**Our Ref:** FP/217/08/

Conversion and change of use of existing residential care home to 4 no private flats  
(Resubmission of FP/99/08)

4 Felpham Road Bognor Regis

Drawing	Scale	Date	Drawing No.
LOCATION PLAN	1:200; 1250	OCT 08	9270/PL2/01
SITE/BLOCK PLAN

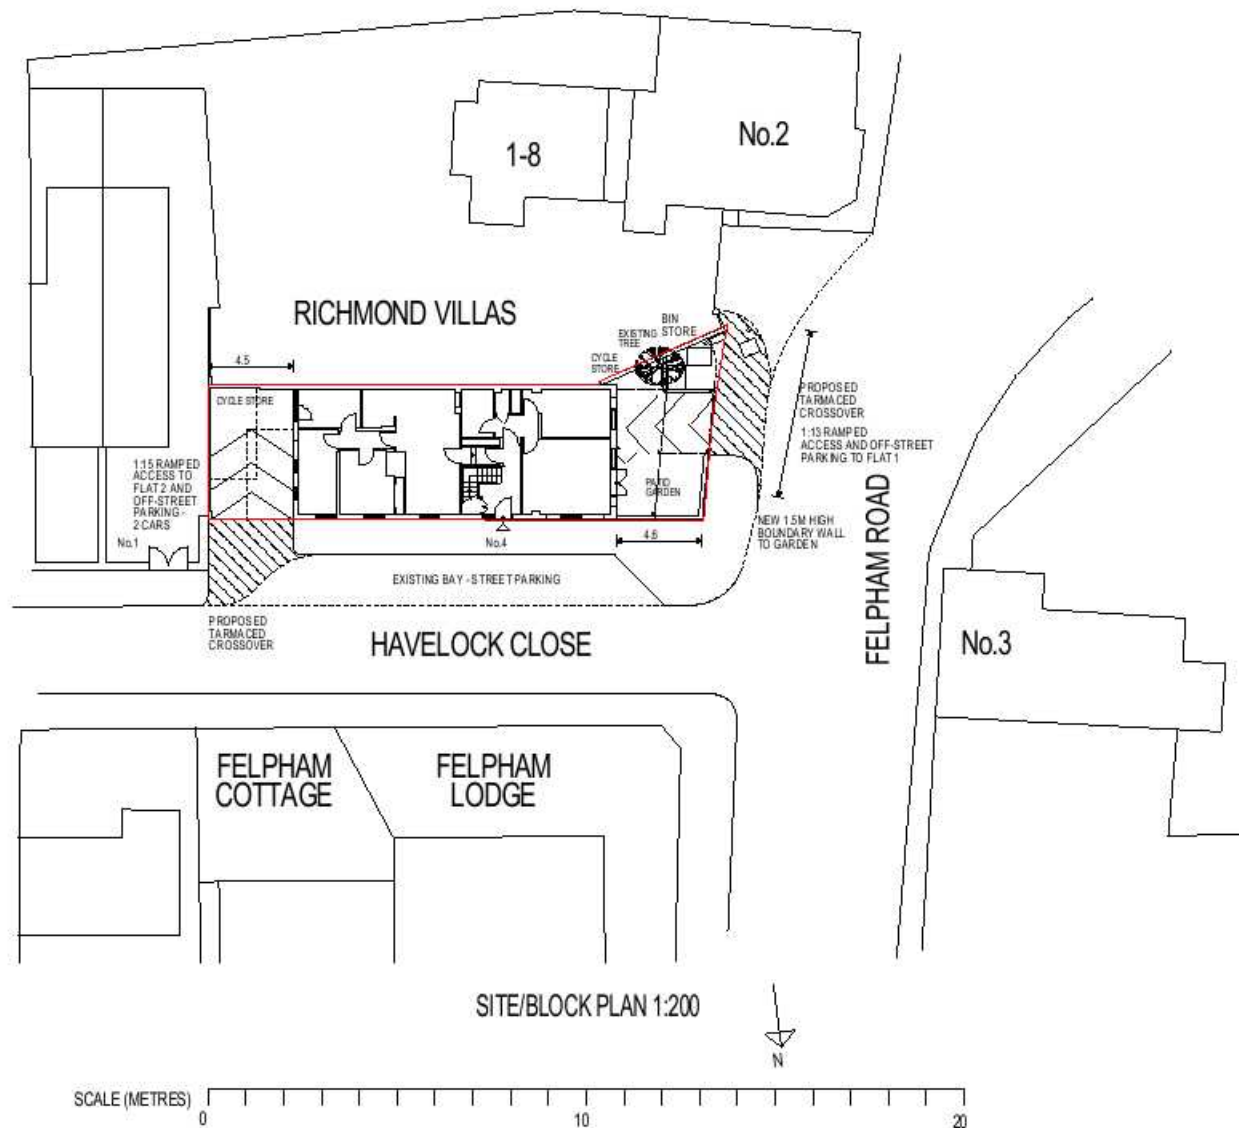
*Committee objected to this planning application on the same grounds as the previous application (FP/99/08) namely concern regarding vehicle access and exits from the car parking spaces adjacent to a busy and dangerous bend on the road.*
